7 November 2017

File No: 2017/556954

State Significant Development application for the Inner Sydney High School (SSD 7610) – Response to Submissions

Sun Studies
June 21st - 204-214 Chalmers St Facade

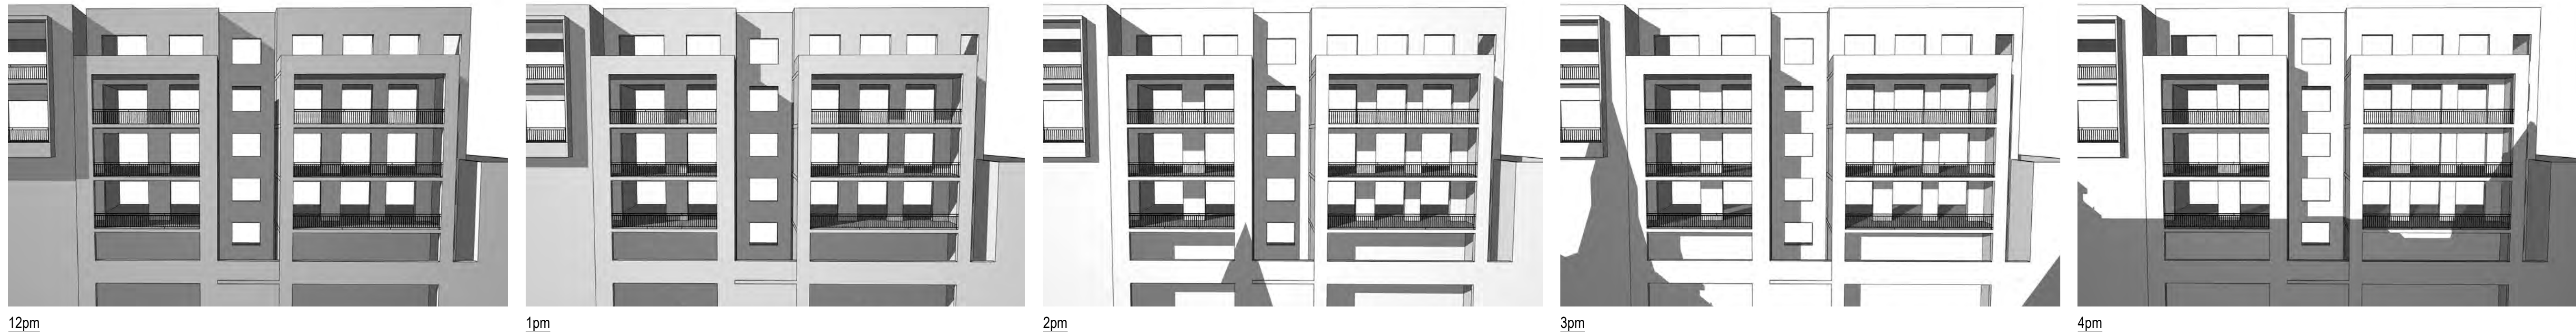
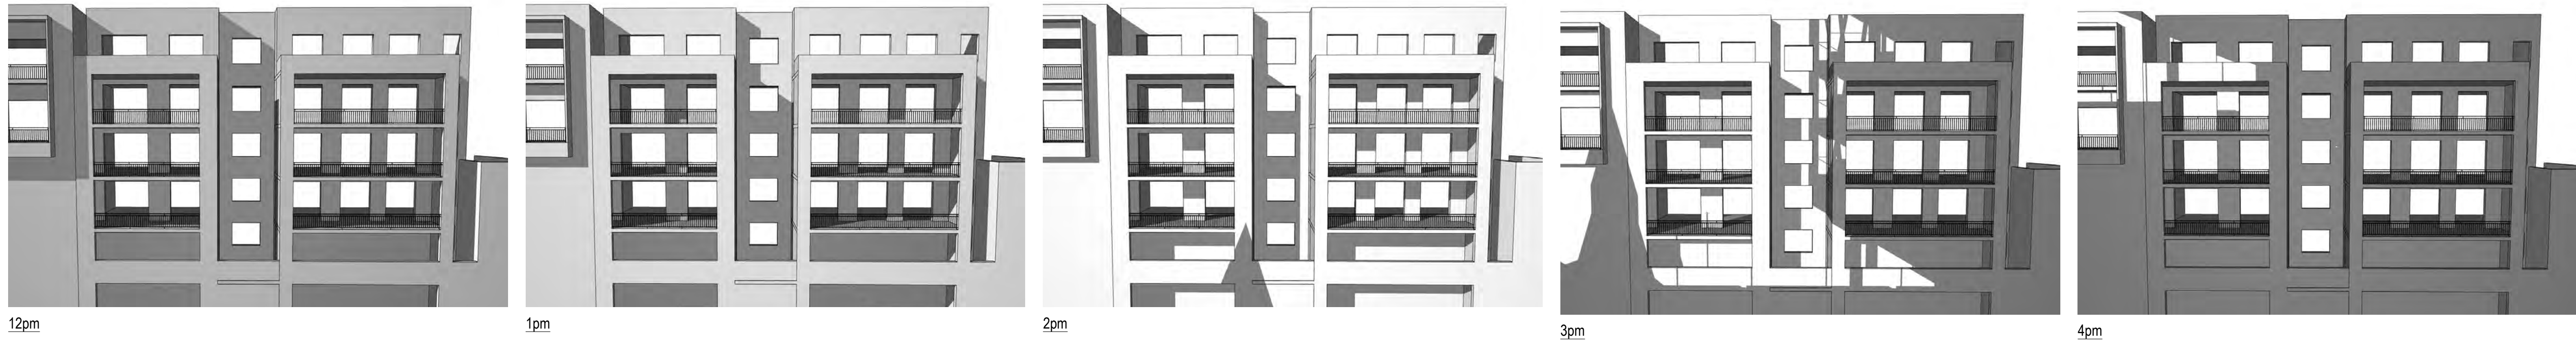
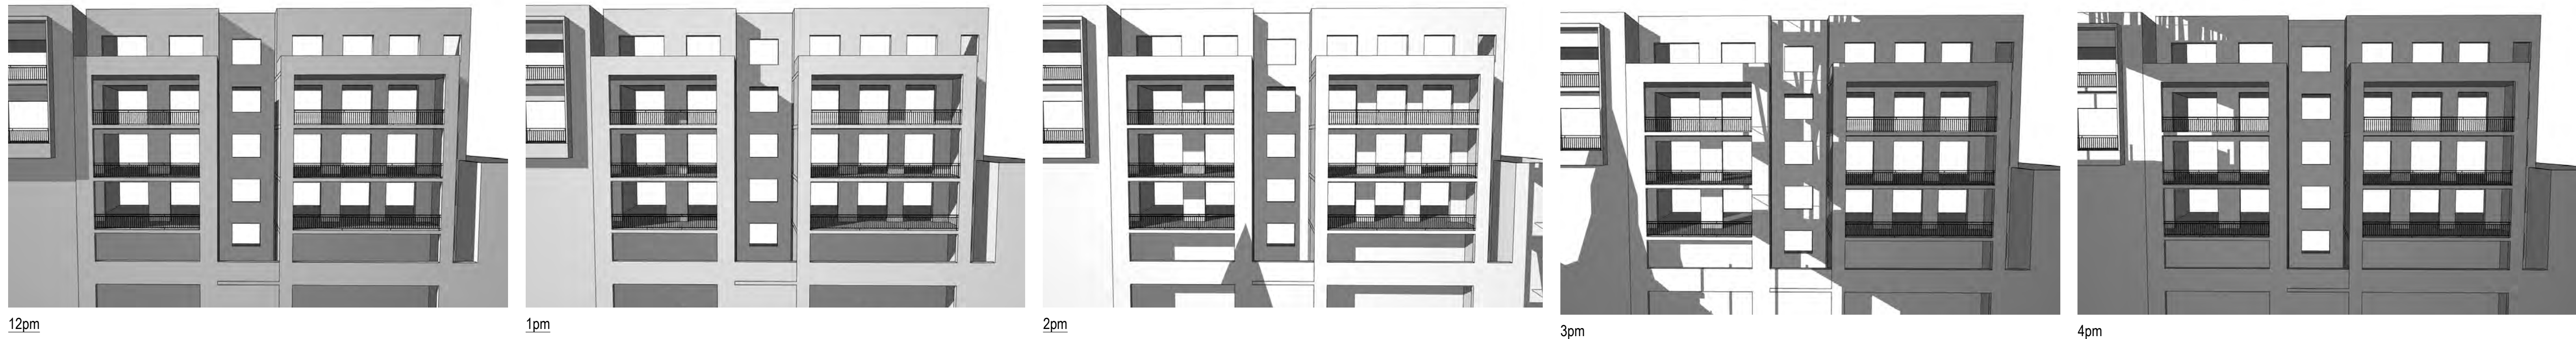
The drawings are unclear in that shadow falling on glazing of 204-214 Chalmers Street is not identified. However, it is clear that the west facing apartments in the south west corner of this building are impacted at 3pm. At midday, the angle of sun is too oblique to the facade to be of any effect. These apartments therefore rely on solar access from some time after midday (possibly 12:30) for the following two hours. In the existing condition, they are compliant.

In the proposed condition, the material submitted shows that solar access is lost at 3pm. This impacts two apartments each at level 1 and 2, and 1 apartment at levels 3, 4, and 5. Without the half hour views, it is not possible to conclude whether these 7 apartments change from a complying to non-complying status. The Department should satisfy itself whether the reduction in sunlight hours results in a solar access non-compliance or not, and whether the resultant amenity is acceptable.
